Application for a non-material amendment following a grant of planning permission.
Town and Country Planning Act 1990

The development proposed is for full planning permission for works and change of use to the Grade II listed Kirk Mill to create a hotel (18 bed, use class C1) and a bar and restaurant (use class A3), works to the barn buildings to create seven holiday cottages (use class C1), construction of a hotel and spa (20 bed use class C1), wedding venue (use class D1), kids club (use class D1) and trailhead centre (use class D1 and A3), change of use of Malt Kiln House from residential use to class C1, construction of a new cricket pavilion (Sui Generis), demolition of the group of derelict factory buildings. Outline planning permission for 60 residential dwellings split over 2 sites with a maximum of 56 and 4 units each, with all matters reserved except for access).

Revision of the access drawing for Plot B. The approved drawing is referenced in condition 4 - TPMA1001 - 108.

SCALE	SHEET	DRAWING No	REV
1:125	A1	3081-SHD-00-ZZ-DR-C-SK001	P1

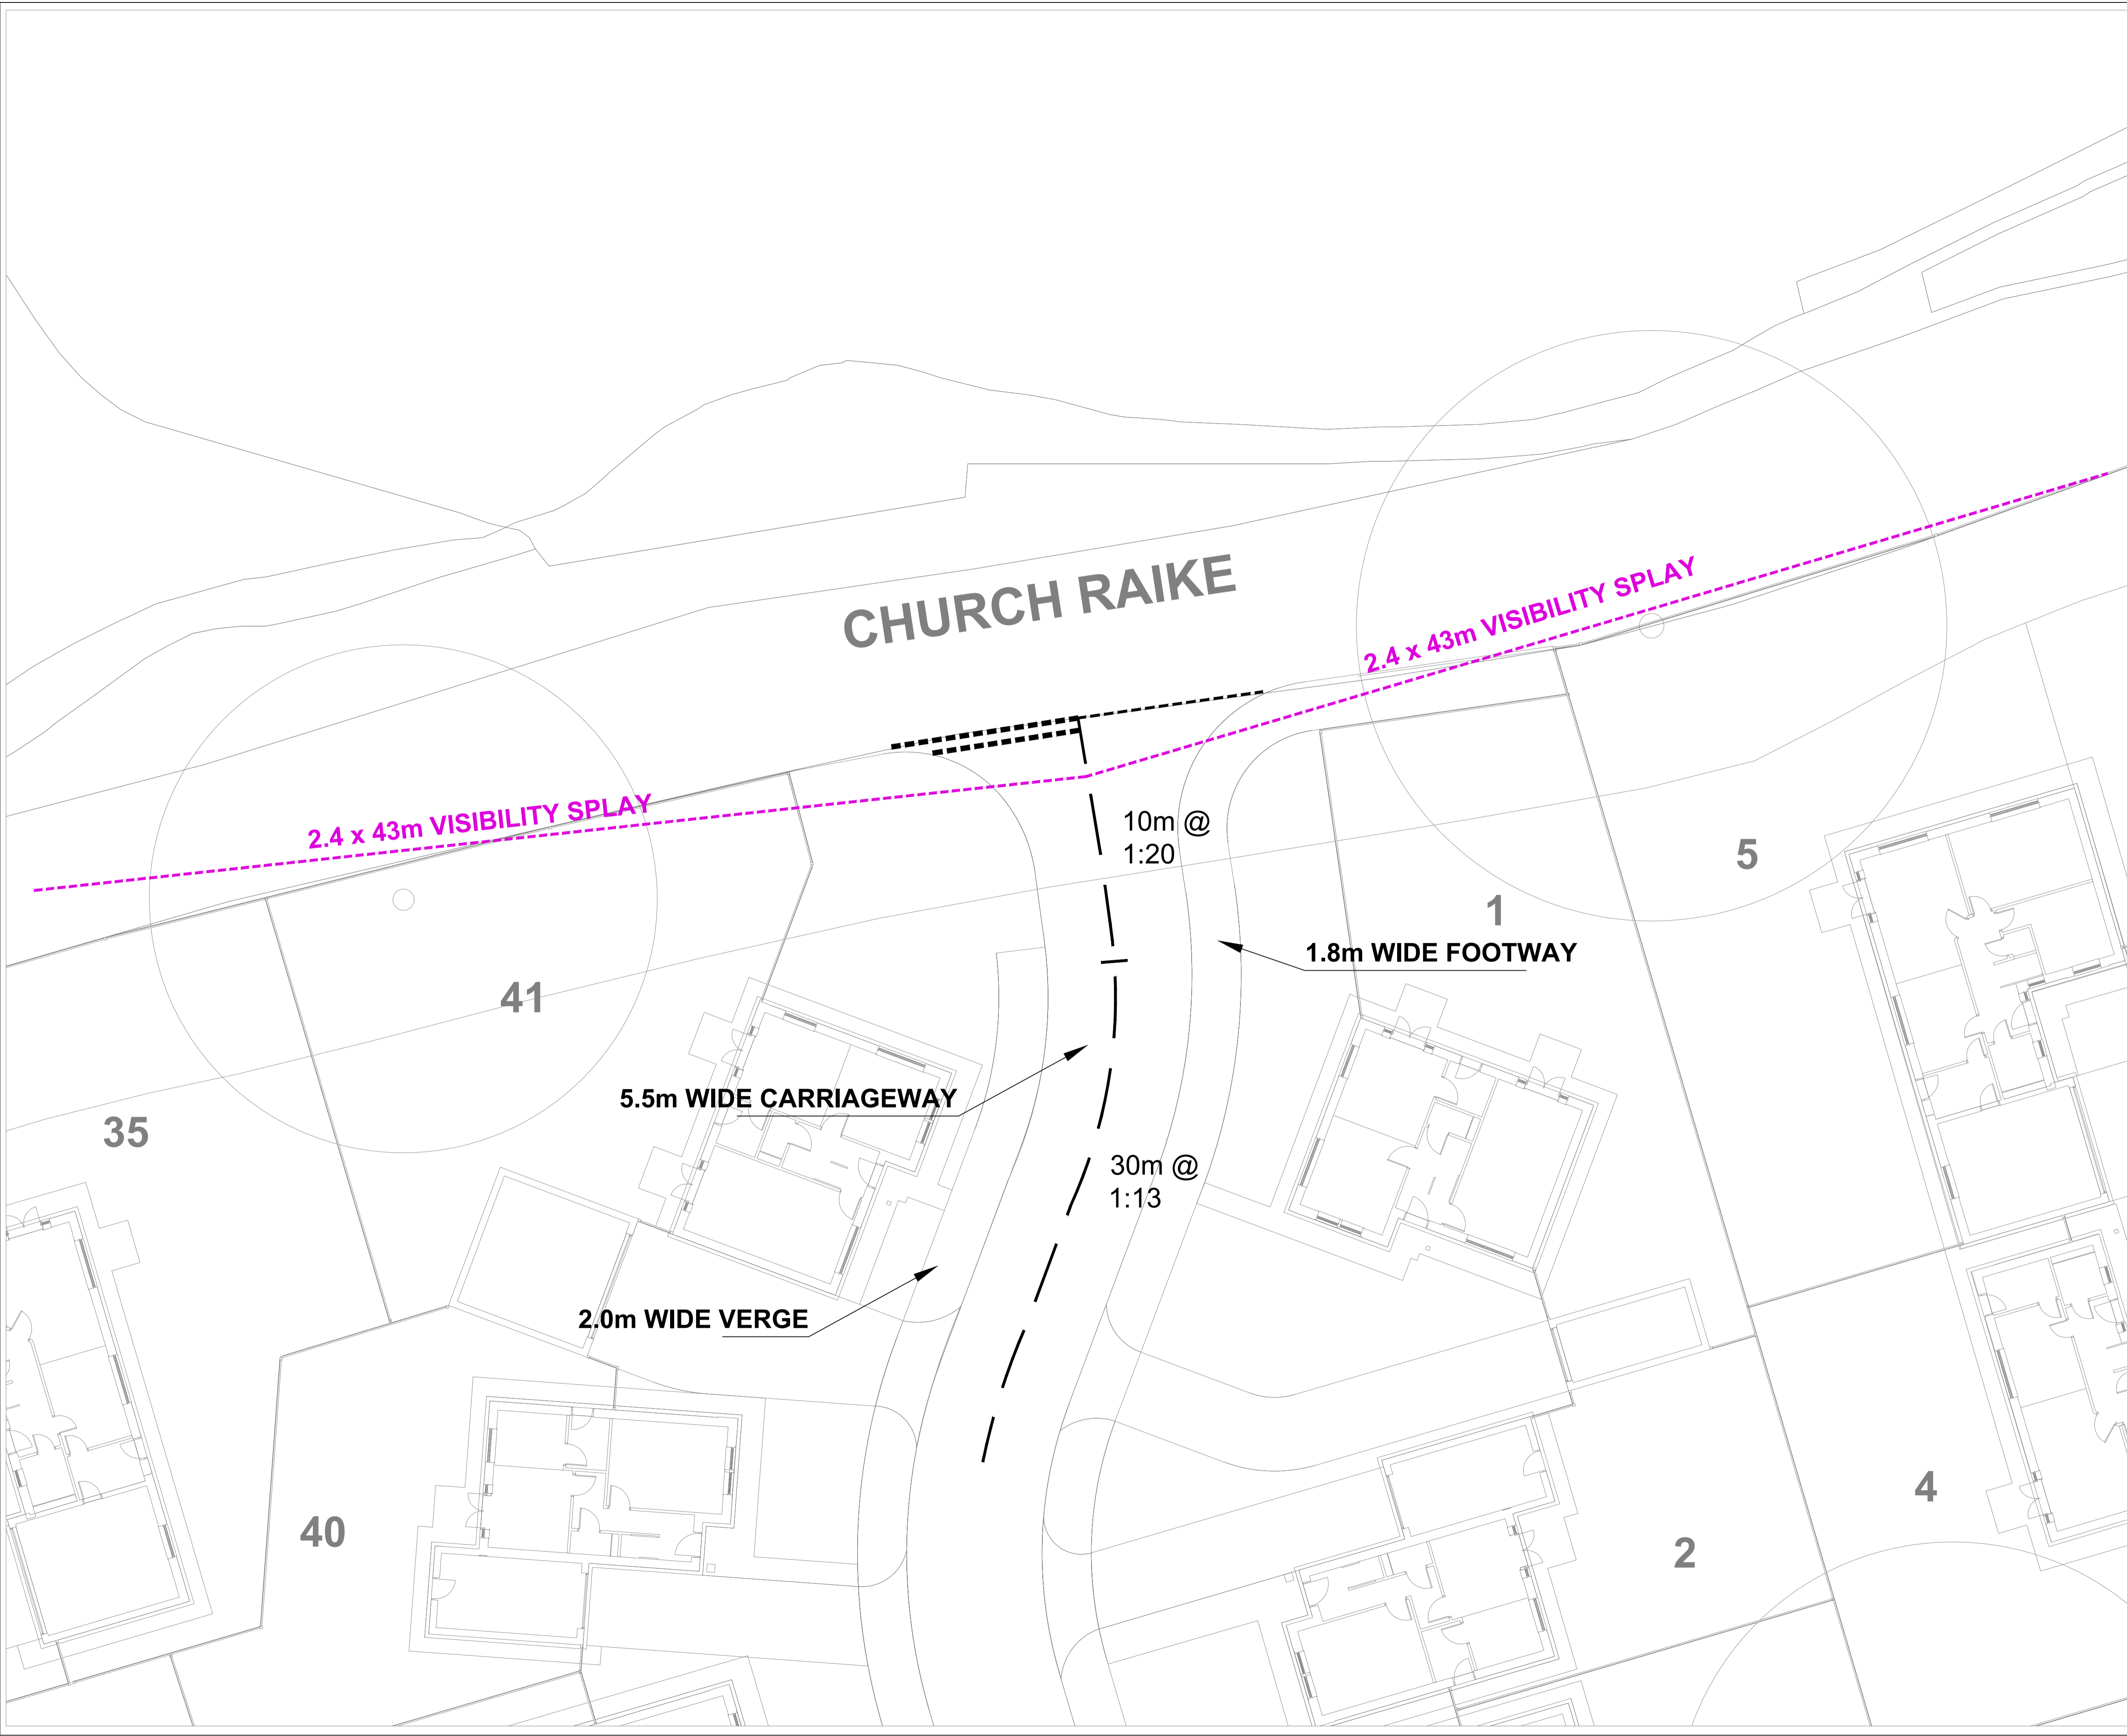
The site access has been re designed to allow for the retention of the tree to the west.

3081-SHD-00-ZZ-DR-C-SK001 P1
